AW-248-13-T – Kingsway – Fell and Lop Trees – Objection – 17-12-2013

**OBJECTION – AW/284/13/T – Fell, Lop and Top trees – Kingsway, within  
the Craigweil House Conservation Area and Area of Special Character**

T 5  
GOLDEN LEYLAND 11

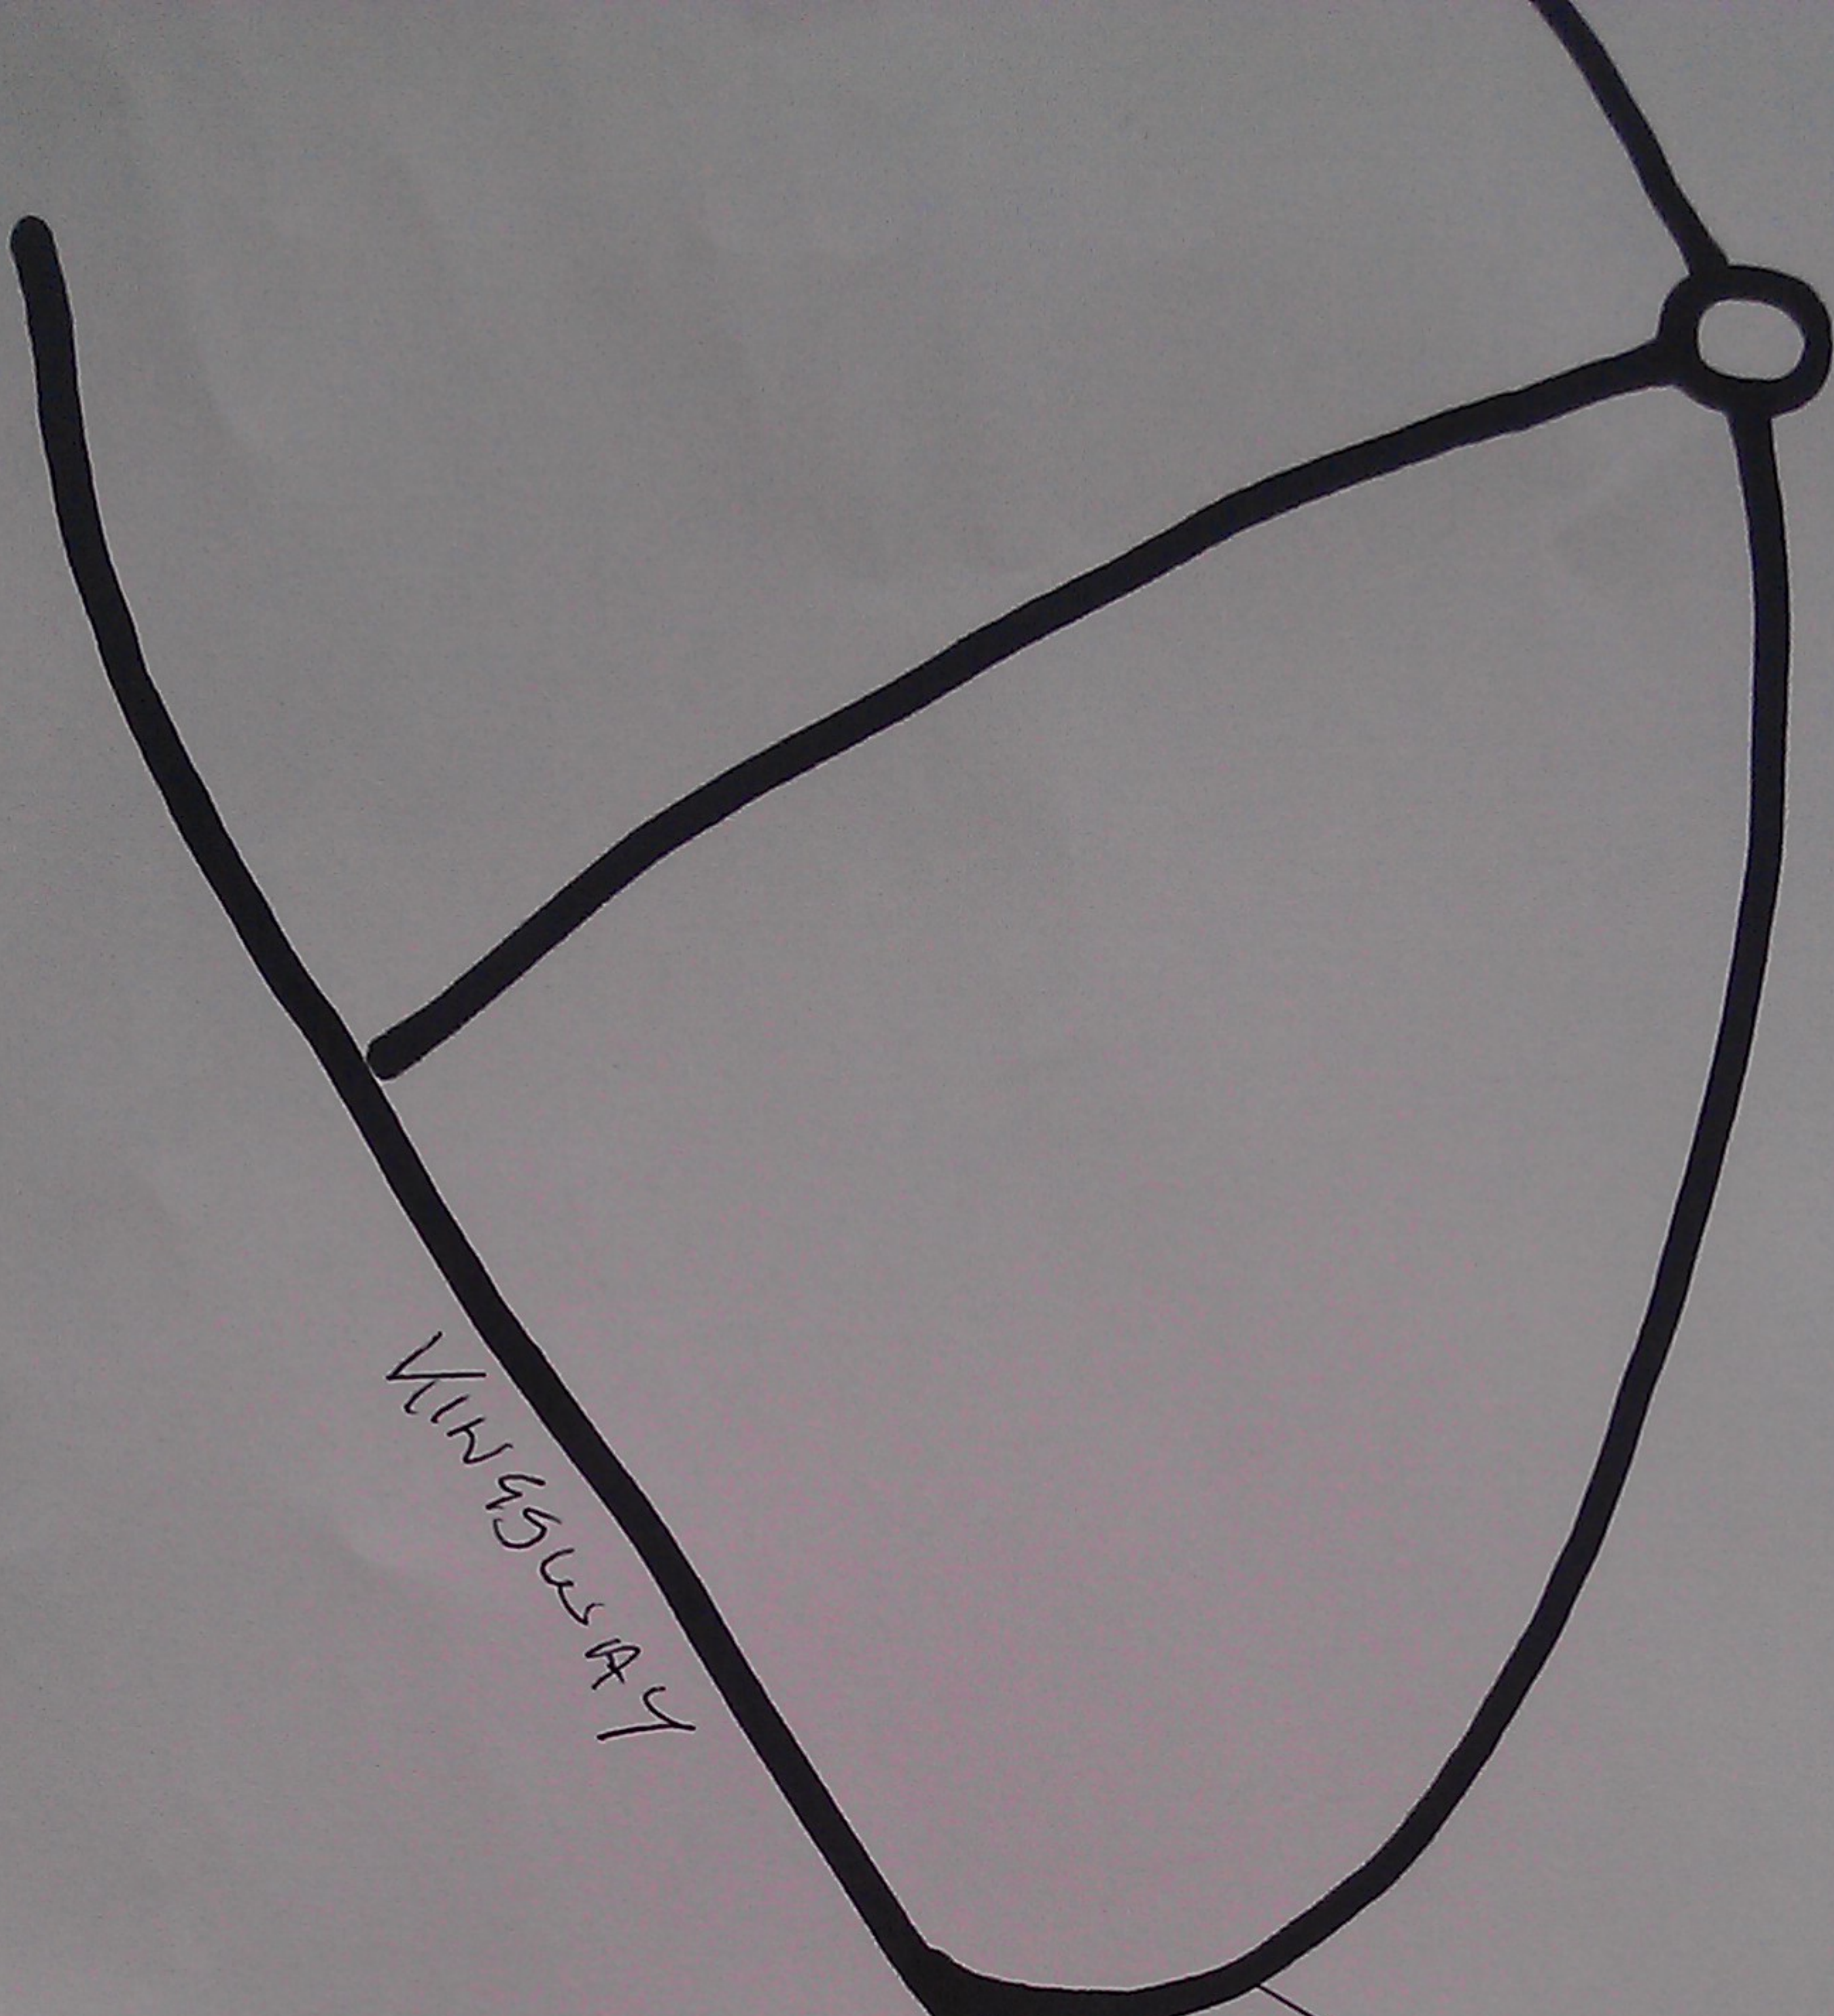
It is clear that if the felling and removal of the Golden Lleylandii (T5) – an extremely attractive, fine tree - was to be allowed then not only would its highly significant visual amenity value be lost but the Root Protection Areas of innumerable nearby trees would be damaged and the trees harmed or killed – contrary to BS5837:2012. None of these trees can be removed without causing extensive damage to many others around.

**CHECAA says that the most important issue in this application is that the Local Planning Authority seriously considers protecting the superb Golden Lleylandii (T5) adjacent to the footpath alongside No. 57 Kingsway and we ask that a Tree Preservation Order please be placed upon this tree under Sections 198 and 201 of the Town and Country Planning Act, 1990 in order that it may take immediate effect. Clearly, this tree is in immediate danger and the Act provides for such a scenario by requiring a 6 week's notification of tree work in a conservation area.**
